LSC RESPONSES TO EPC TIS REDLINE COMMENTS

Davis Ranch Subdivision Master Traffic Impact Study (LSC #S224640) July 7, 2023

Add PCD File No. SKP232 ¹

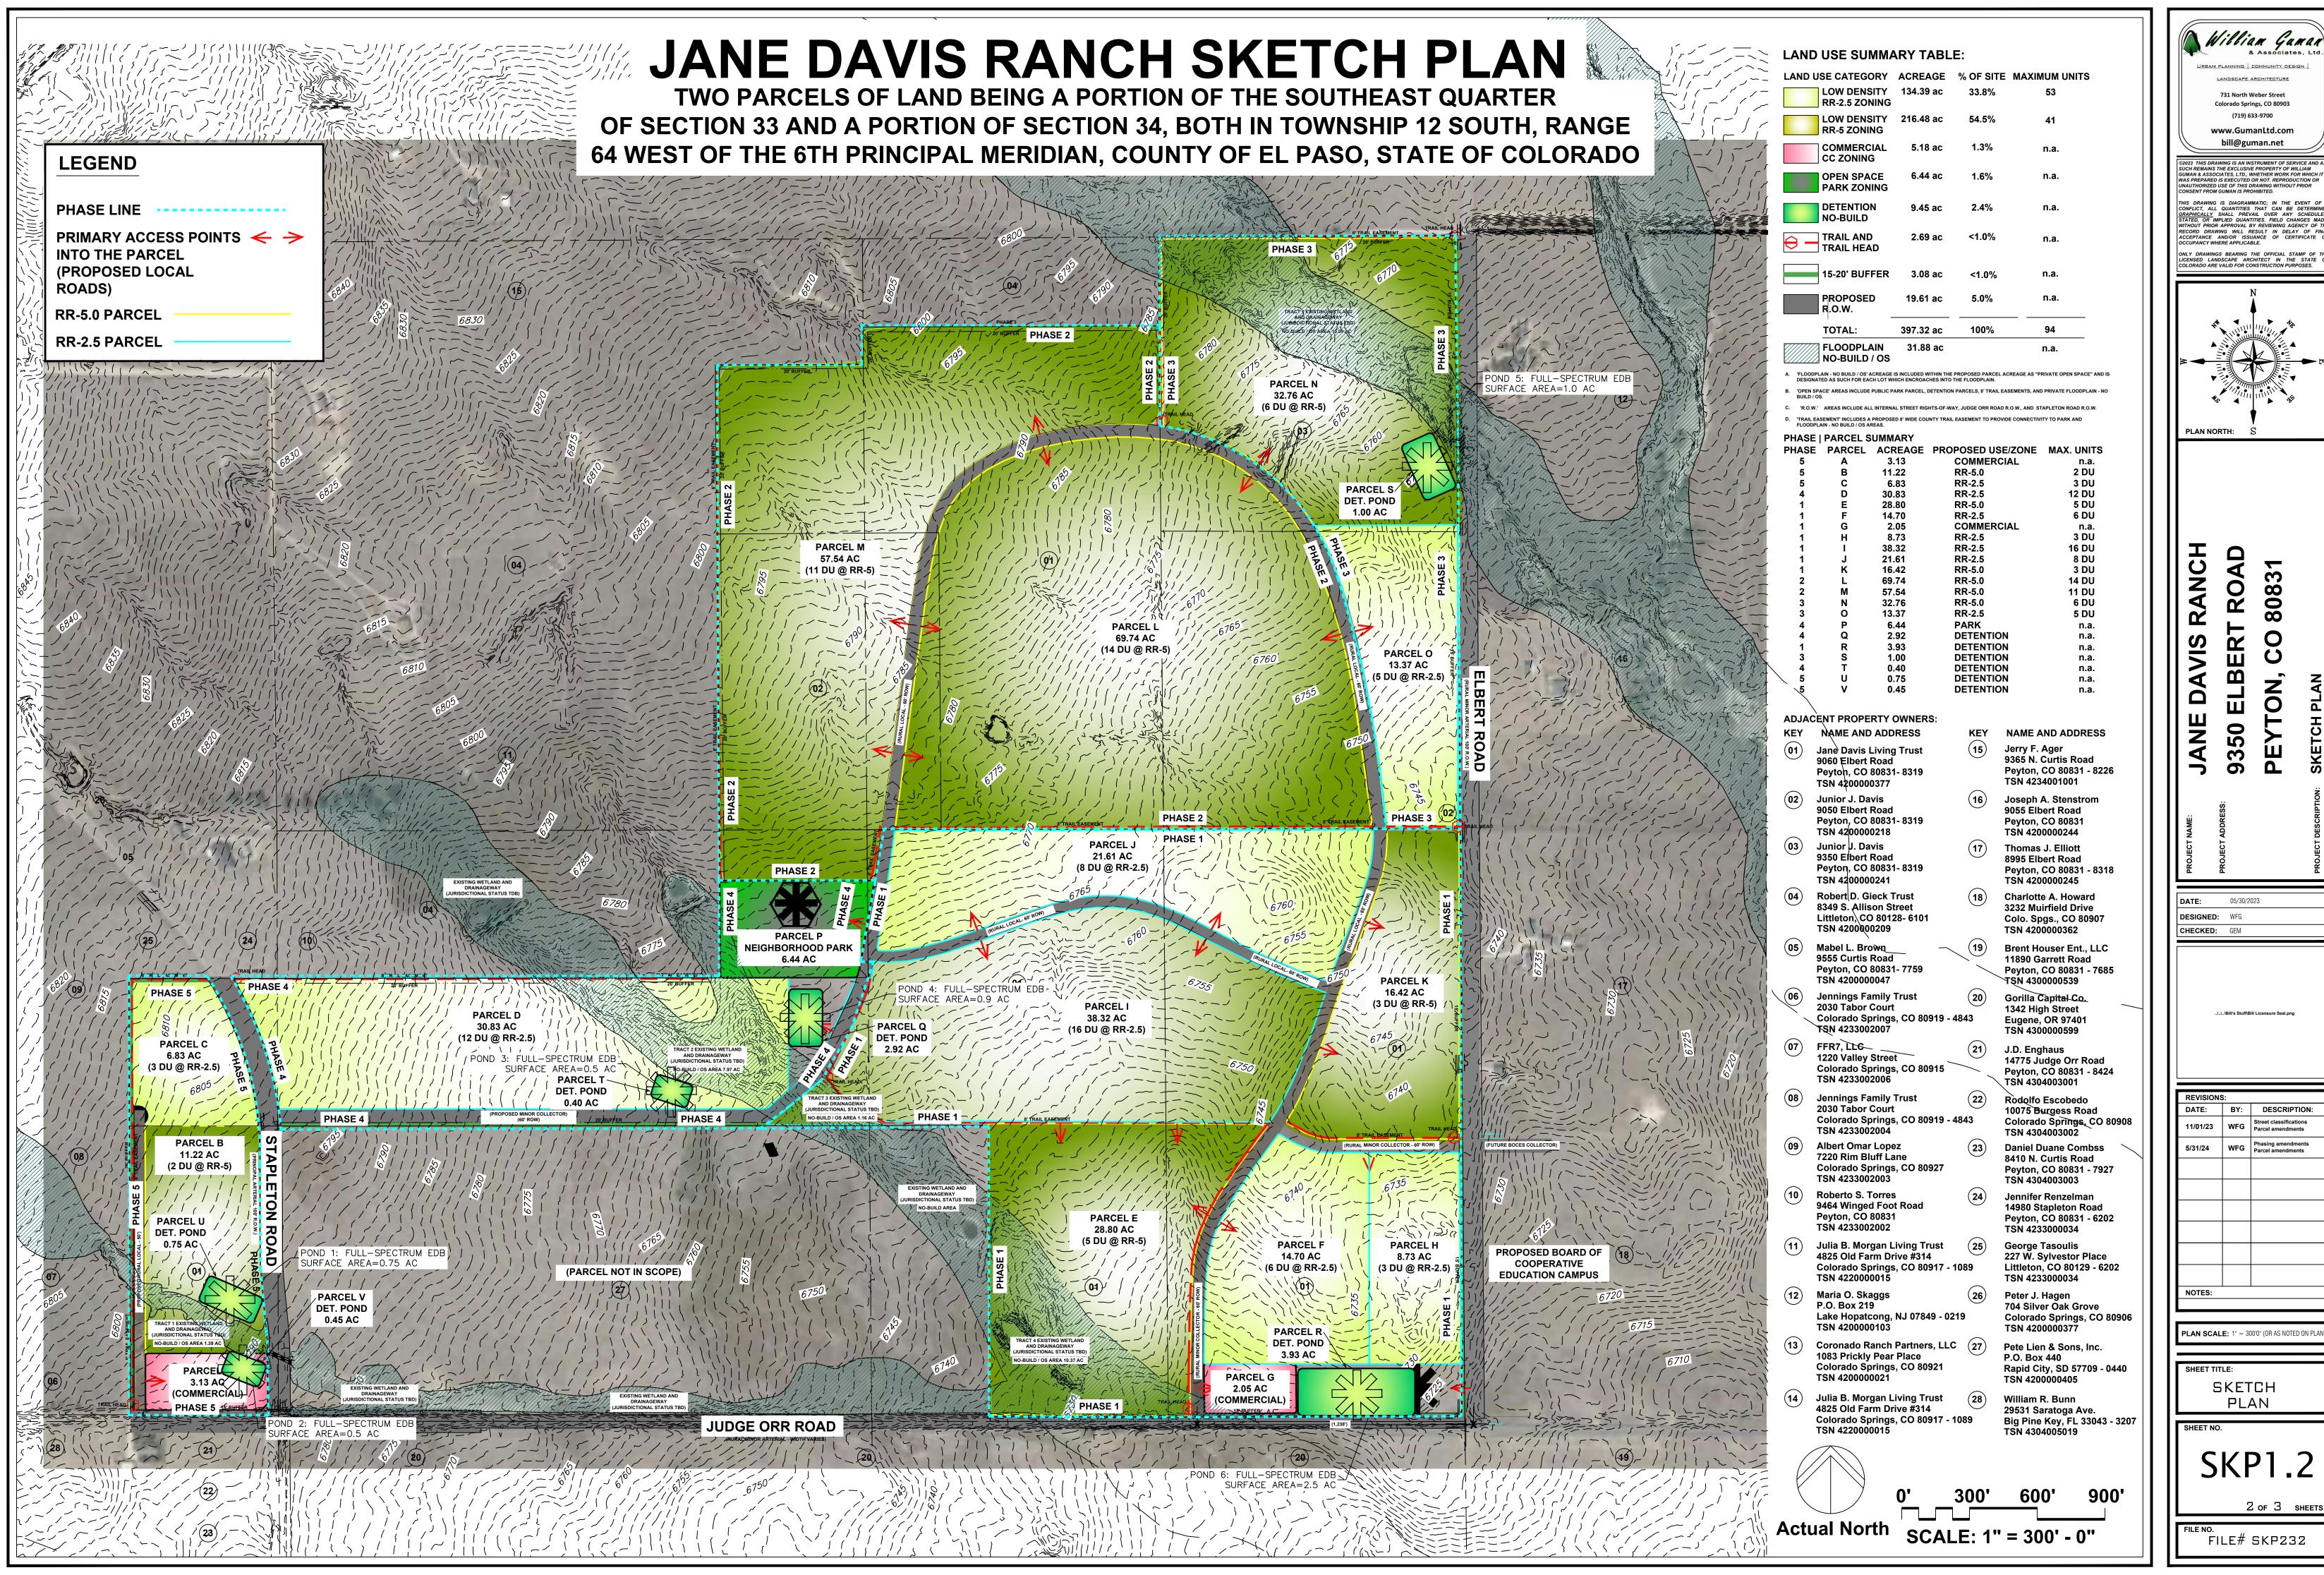
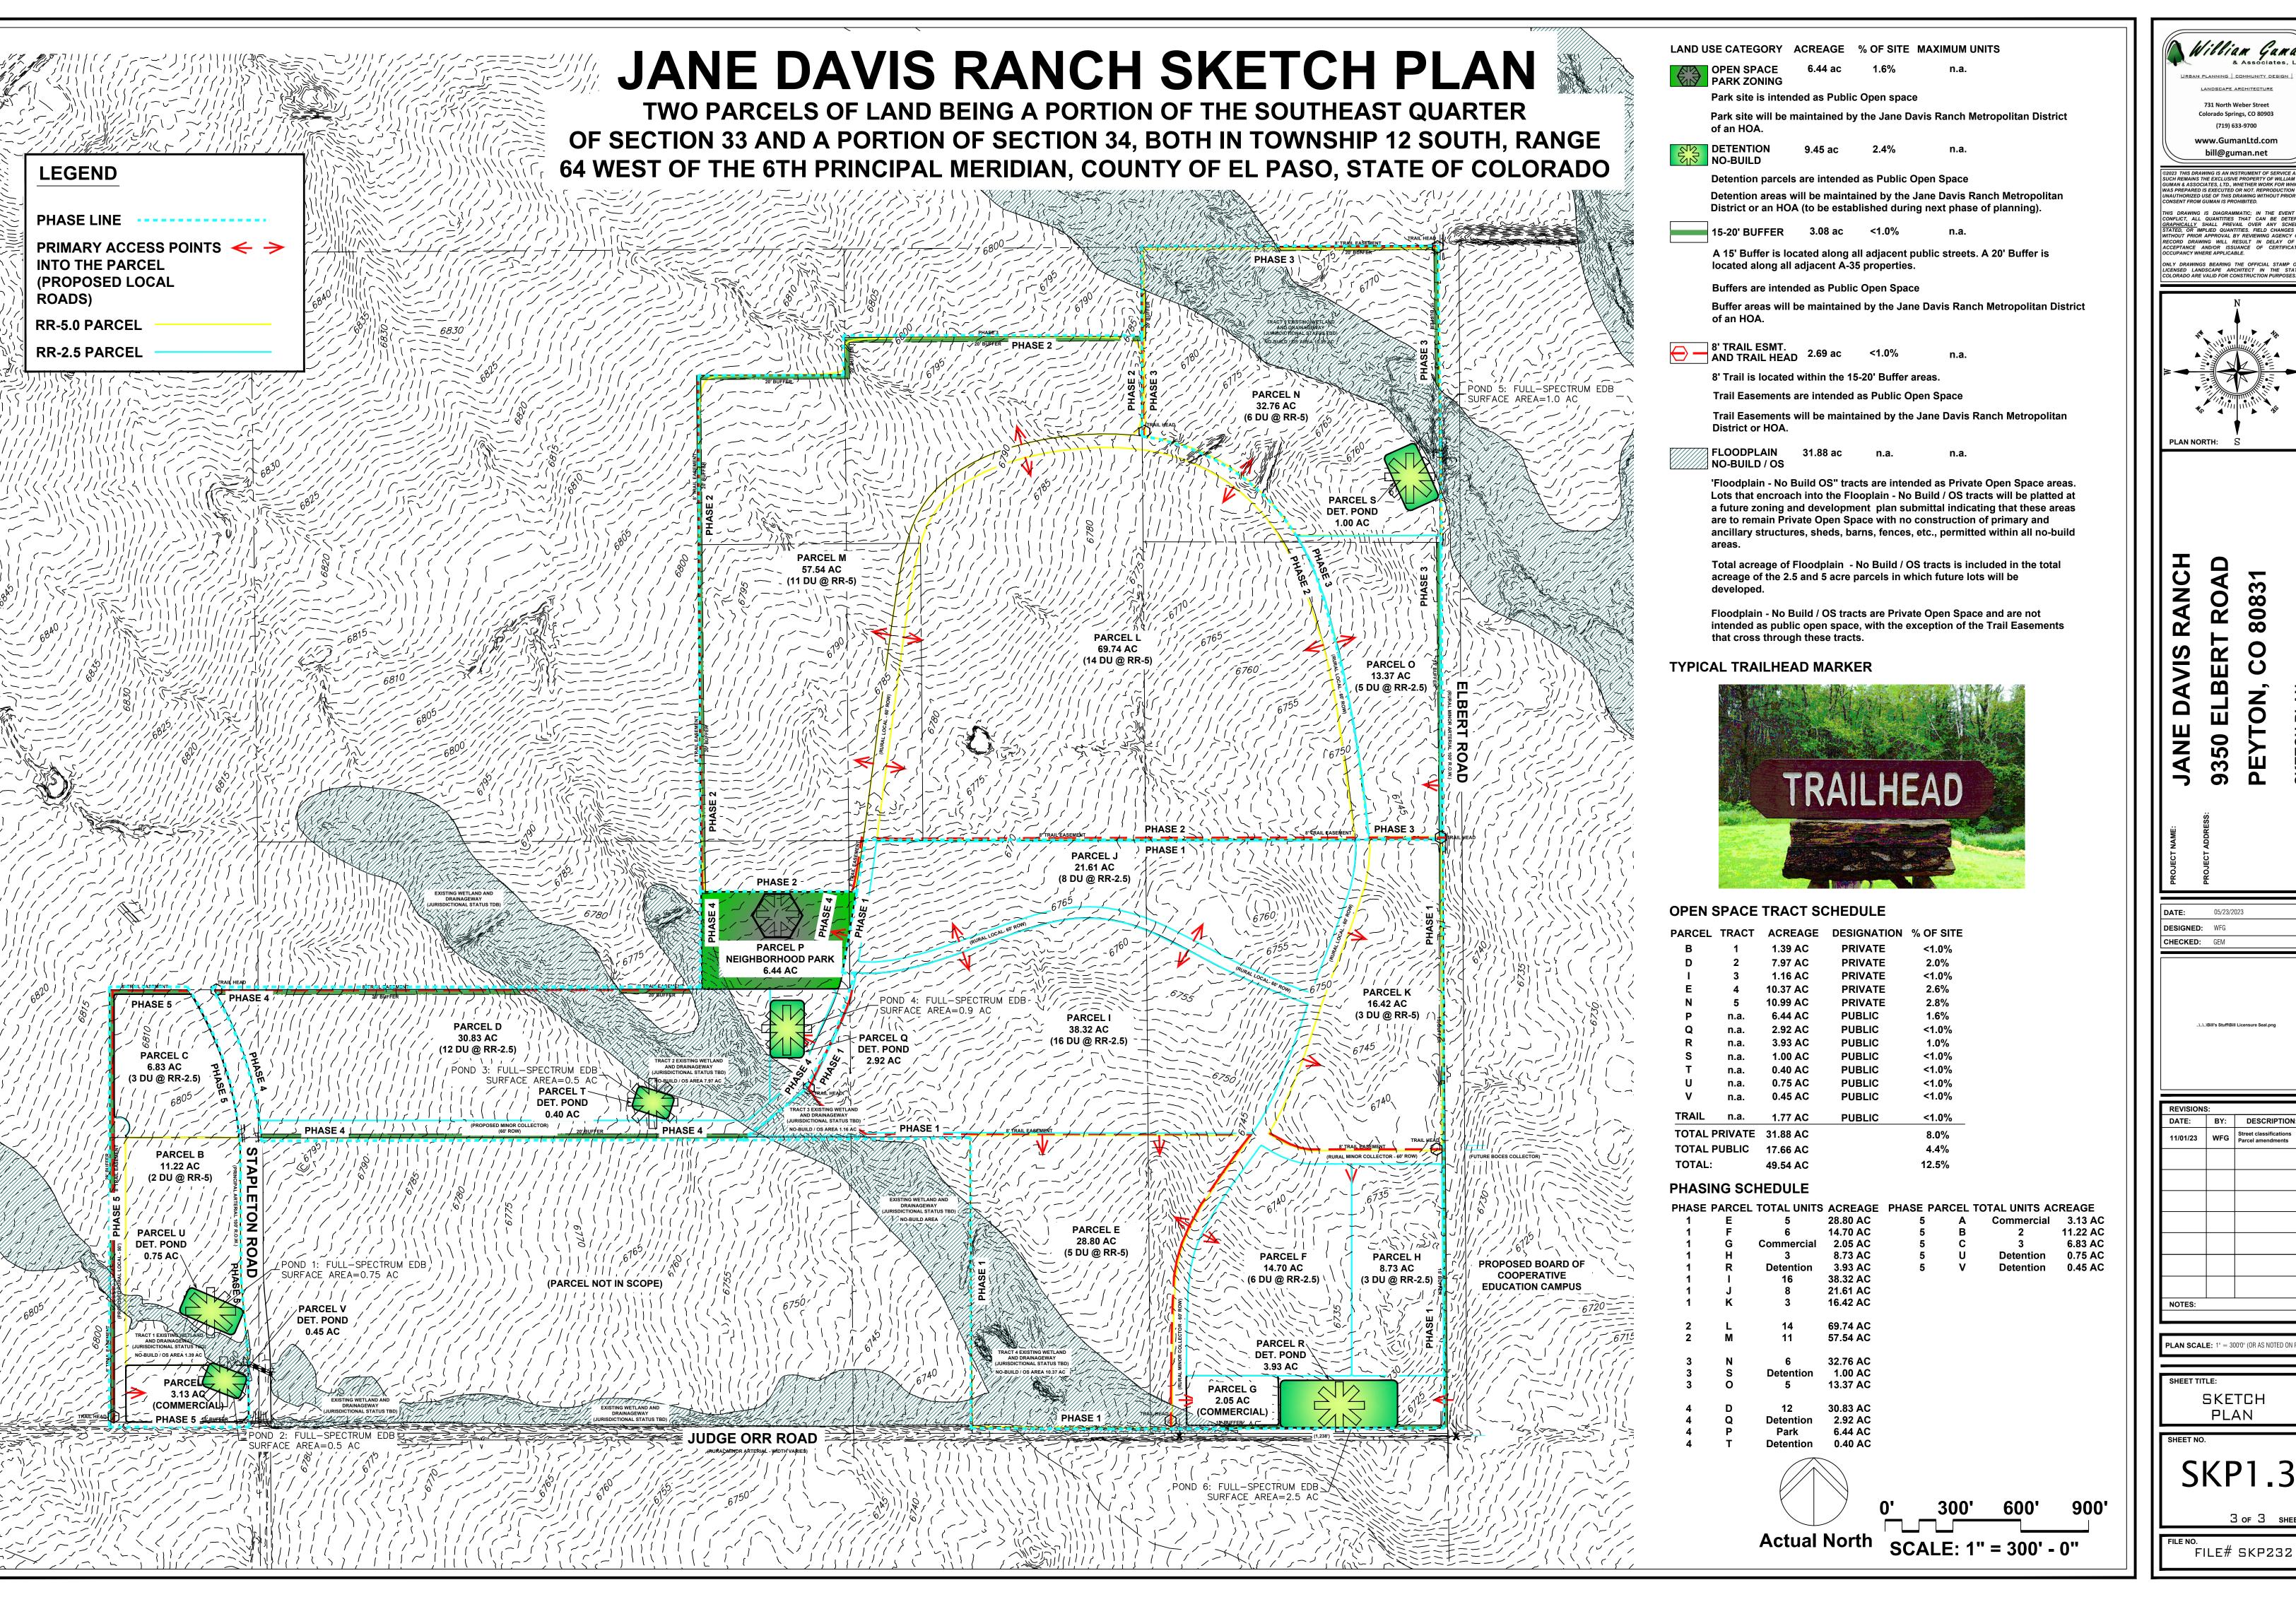
Please revise the traffic analysis as it was determined that no access would be allowed along Stapleton as 1/2 mile spacing is not met and access proposed is not identified on the Stapleton corridor plan.

note shown on the sketch plan. Please coordinate with the planning consultant so that the sketch plan and TIS are consistent

LSC Response: The access on the west side of Stapleton has been removed. The access on the east side remains, as no frontage on Judge Orr is available and a connection for access to the north does not exist. The volume projected to utilize the access would be low and it is unlikely that a signal warrant would be met. In the future, this access could potentially be restricted or closed if/when additional street connections become available through adjacent properties.

LSC Response: The TIS now matches the sketch plan.
